PLANNING DEPARTMENT – Development & Building Services

RE: Dairy Queen at 6370 Coors NW – Grading & Drainage Plan for Building Permit
Bosque Plaza, Lot 6A P.E. Stamp: 8/7/12 (E12-D006A)

Based upon the information provided in your submittal received August 8, 2012, the above referenced plan cannot be approved for Grading and Building Permit until the following comments are addressed:

ENGINEER'S SEAL  RONALD R. BOHANNAN P.E., #7868	DAIRY QUEEN		DRAWN BY: B.J.F.
	SWALE EXHIBIT		DATE 12-29-05
	 TIERRA WEST, LLC 8509 JEFFERSON NE ALBUQUERQUE, NEW MEXICO 87113 (505)858-3100		SHEET # C2A
			JOB # 230141

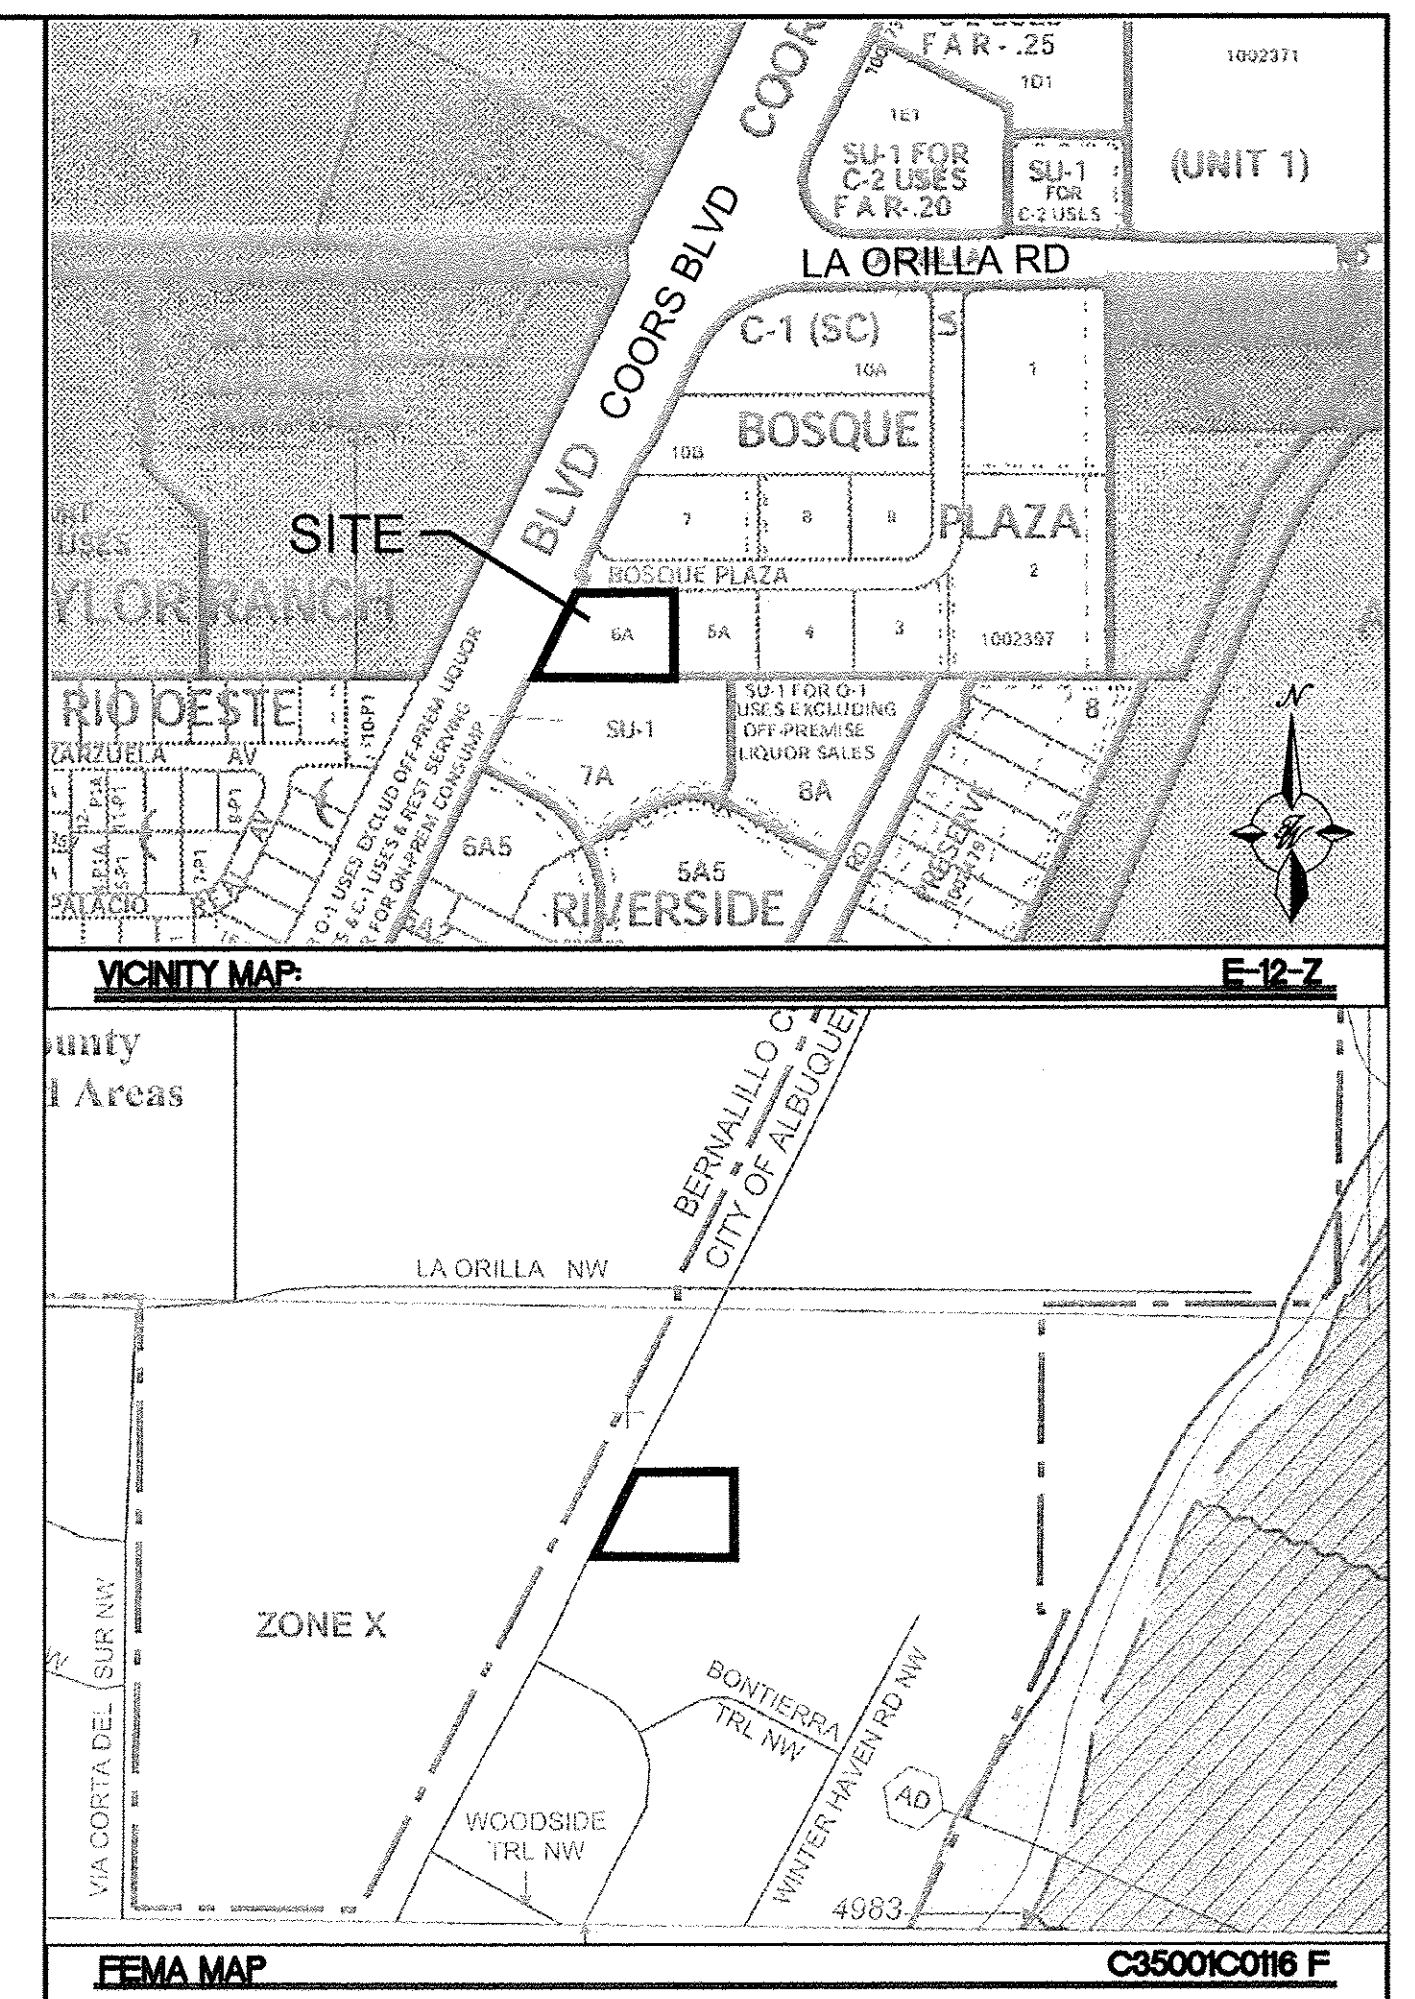
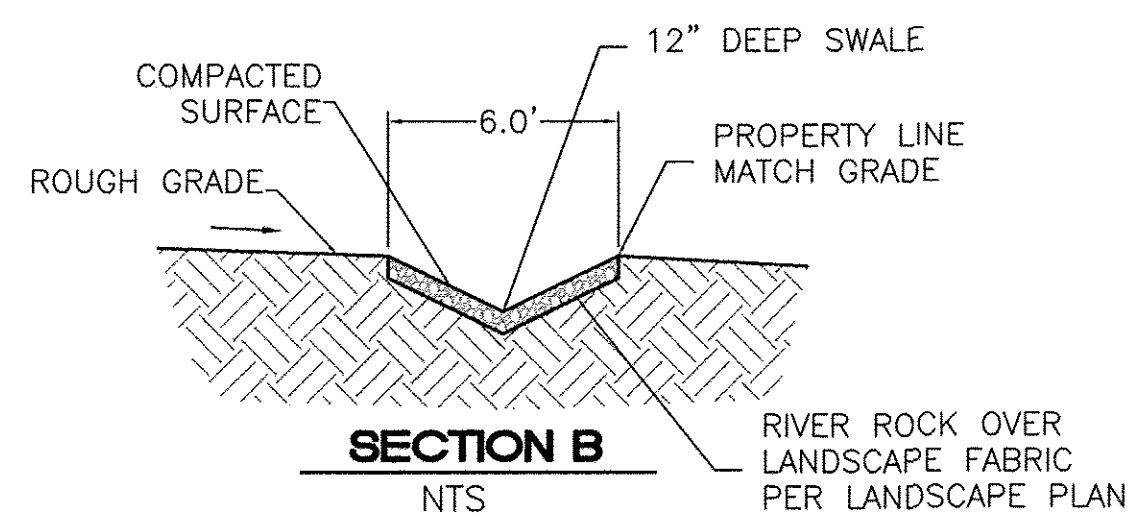
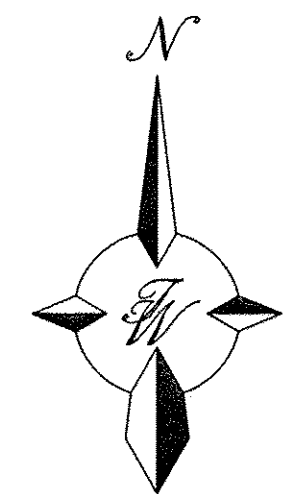
4. Sh. C2: Label the Sidewalk along east property line.
5. Sh. C2/C2A: Plans call for grading and approximately 2' of fill along portions of the west edge of Tract 5A, as well as grading and channel improvements along the south and east sides of that Tract. Provide written confirmation of concurrence from the owner of Tract 5A, in support of the dated grading plan for this work.

6. Sh. C2A: The proposal for a curb opening on Bosque Plaza Lane is unacceptable as shown. Per discussion, provide a COA Standard Sidewalk Culvert, per COA Stnd Dwg. 2236, extending to the property line, or at least 2' south of the future back of sidewalk. The call out should in clued recent amendment to tack weld the cover plate screws, after installation.

7. Sh. C2A: Include County Clerk recording information for the "7' Private Drainage Easement."
8. Sh. C2A: Section C appears to show off site grading on lot 4. Provide dimensions for this offsite work, and written concurrence from the owner(s) of Lot 4 for this work.
